Liverpool Range Wind Farm SSD-6696-Mod-3: Council Response

1. Introduction

Liverpool Range Wind Farm – Modification 3 (SSD-6696-Mod-3)

Table A1 – MOD-3 Changes to Consent Conditions

**Liverpool Range Wind Farm**  
Over-dimensional (OD) and Heavy Vehicle Access - Wind Farm

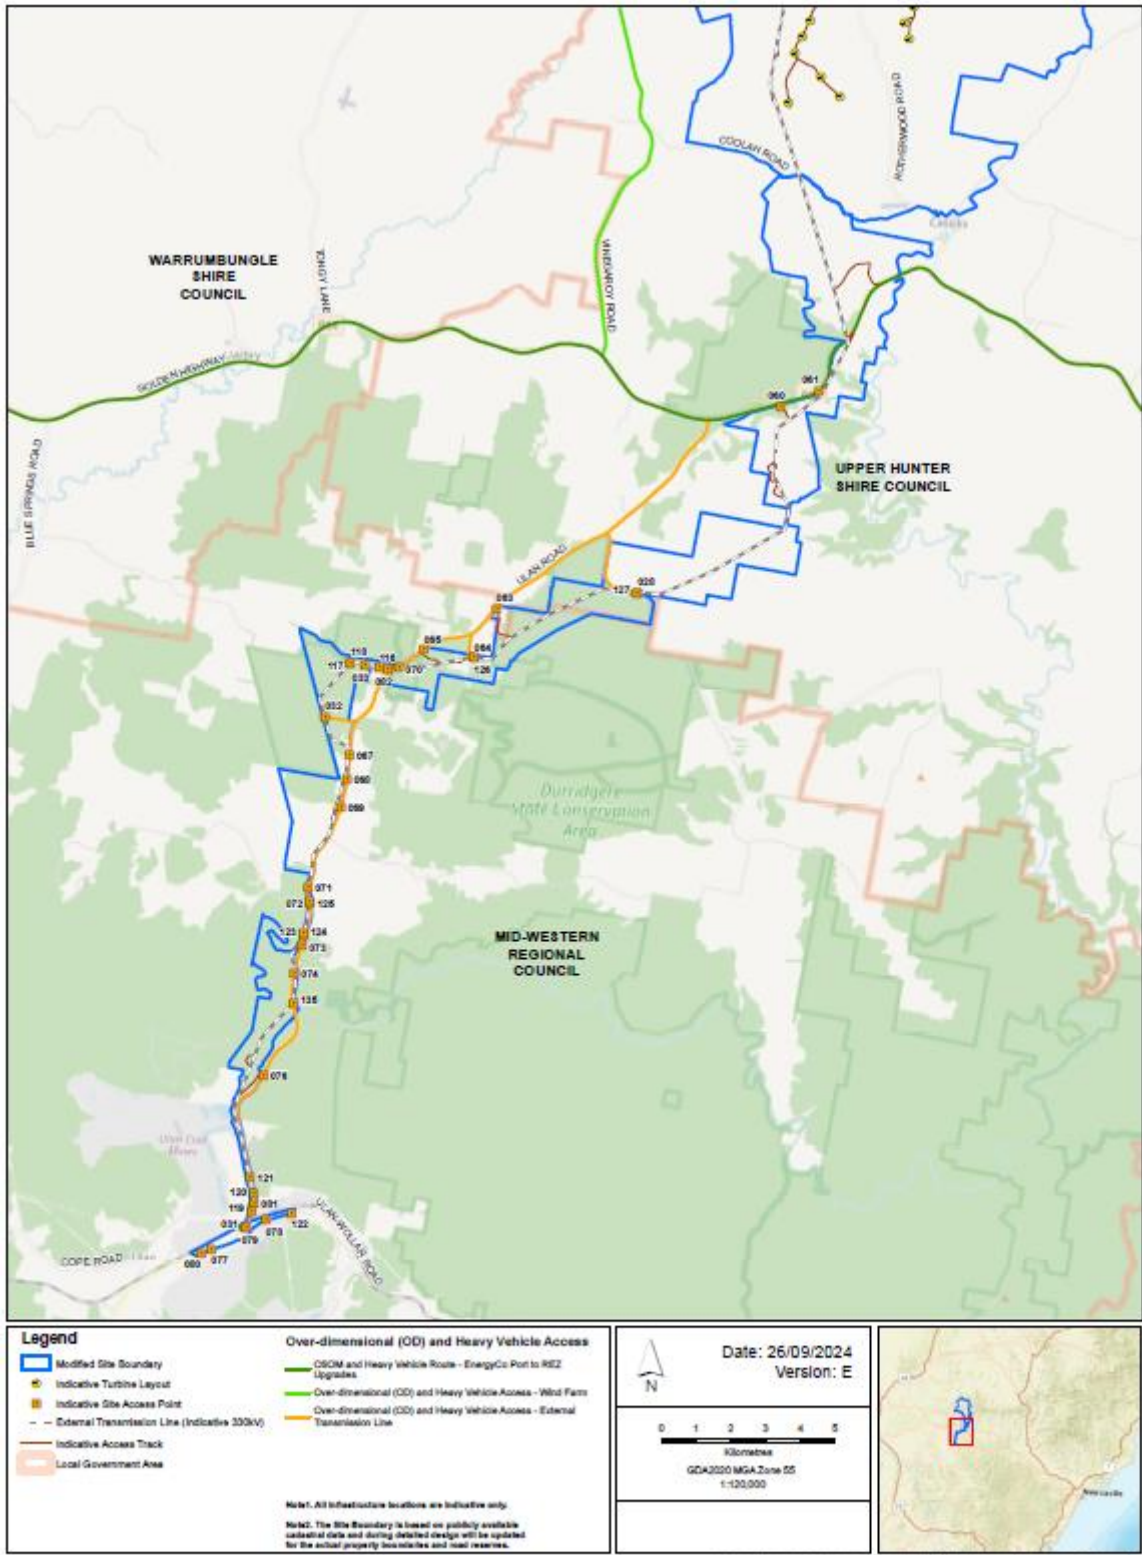
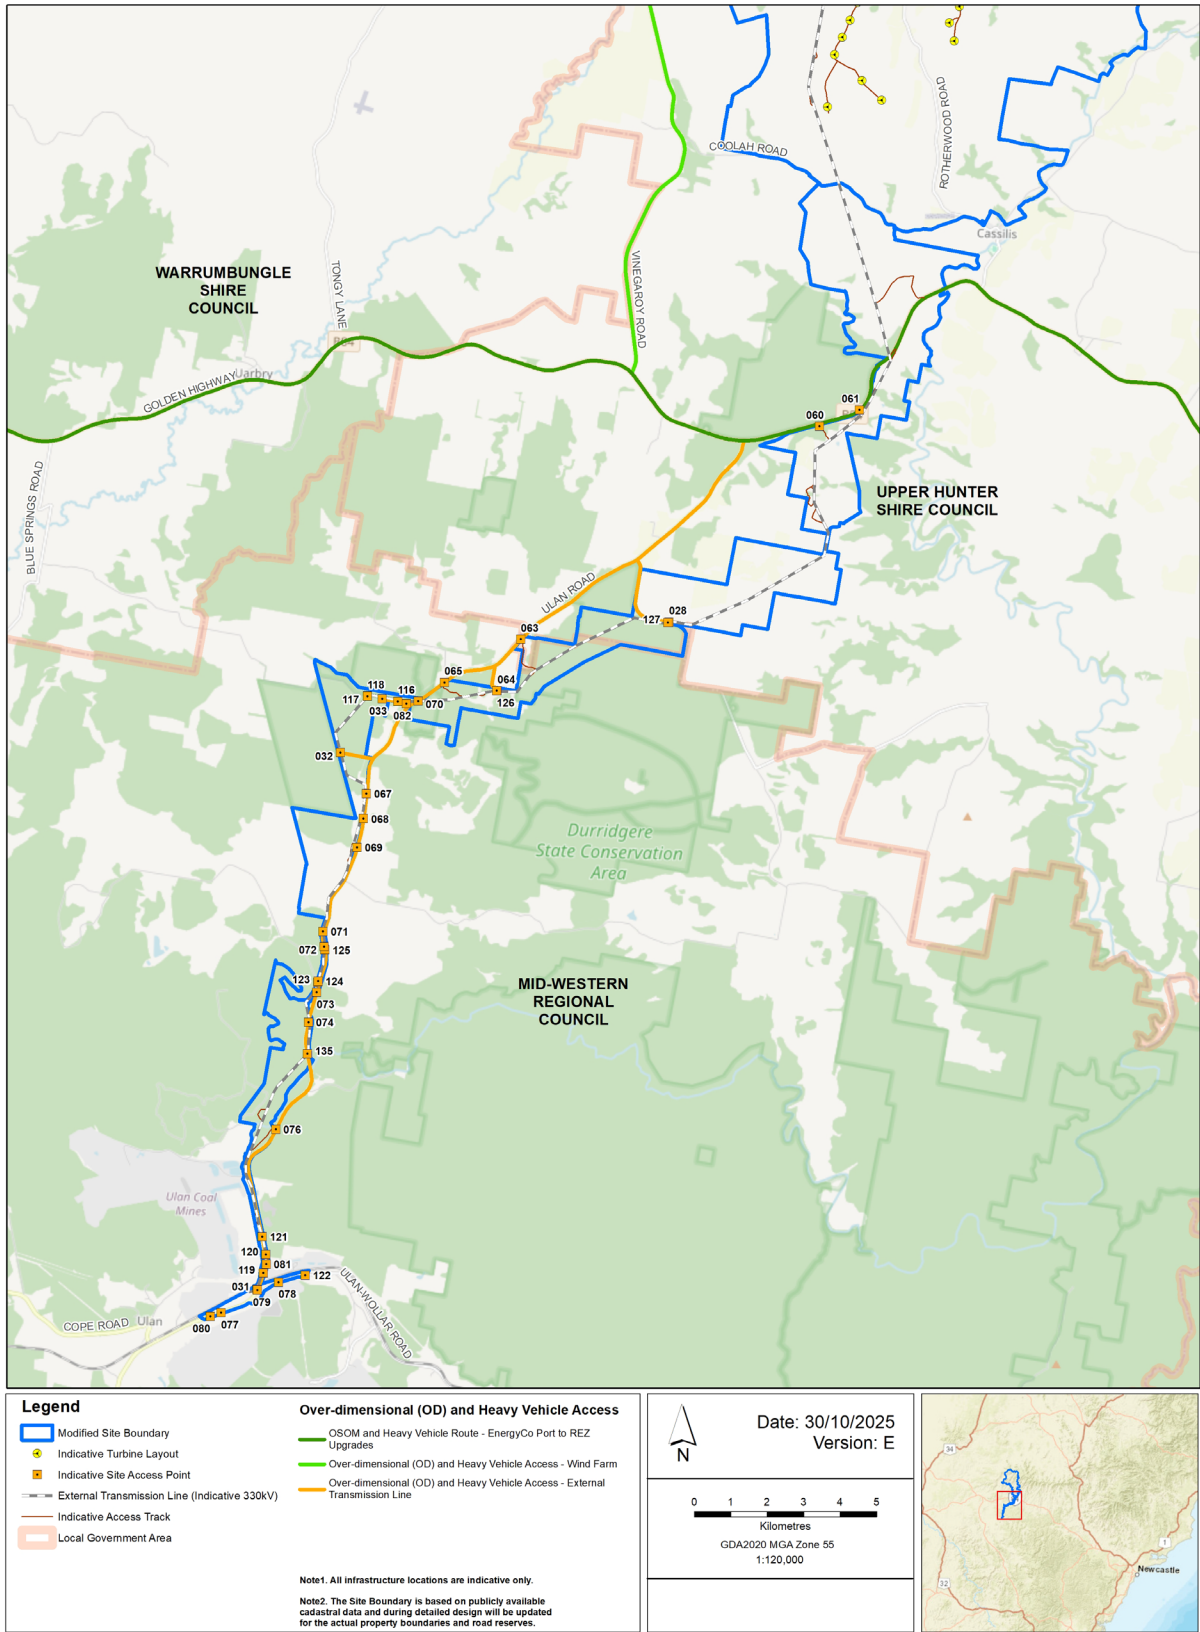
Because Turee Vale Road or State Forest Road are to no longer be used, Mod-3 is likely to substantially increase impacts along most of the other project roads which provide sole access to each Cluster, including Vinegaroy Road, Coolah Creek Road, Rotherwood Road, Pandora Pass Road and other minor local roads. This conclusion is reached when compared with the approved baseline which consists of the approved LRWF Mod-2 project, along with the optional use of the Rotherwood Road LRWF Quarry approved under separate Major Project SSD-68063715.

Council thus urges DPHI to make Tilt Renewables and all other REZ developers more accountable for firstly ensuring real time traceability of its traffic and secondly ensuring its traffic does not use unauthorised access routes. Furthermore, that if their traffic is route non-compliant then the developer must pay the related costs of repair and maintenance. In light of this, Council requests the following be added into the scope of the Traffic Management Plan (Condition 31):

Condition Number (App M Request #ID)	Applicant Request	Council Position	Comments
			Coolah Creek Road / Gundare Road (northeast end) Nil, as project traffic is prohibited on the northeastern end of Gundare Road.
			Minor Access Points on WSC roads BAL and BAR generally, except to the extent turn volumes are shown to peak at less than 5 vehicles per hour during construction.
Council Issue #2	Route restrictions for deleted State Forest Road and Turee Vale Road construction routes	To be Conditioned	The Appendix G TIA Section 4.2.1 states ‘due to the removal of State Forest Road as a proposed construction traffic route, approximately one-third of vehicle movements from State Forest Road will be shifted to other public roads in the project’s construction traffic network.’ It is unclear if the intent is two-thirds of Project traffic (e.g., light vehicles) will remain permitted to use State Forest Road(?). The Table 10 traffic volume estimates do not list State Forest Road. Council requests the Department impose a consent condition that explicitly states that all project traffic (light, heavy and OSOM vehicles) shall only use the approved routes, expressly identifying Turee Vale Road and State Forest Road as being <u>unauthorised</u> routes for Project-related traffic of any type.
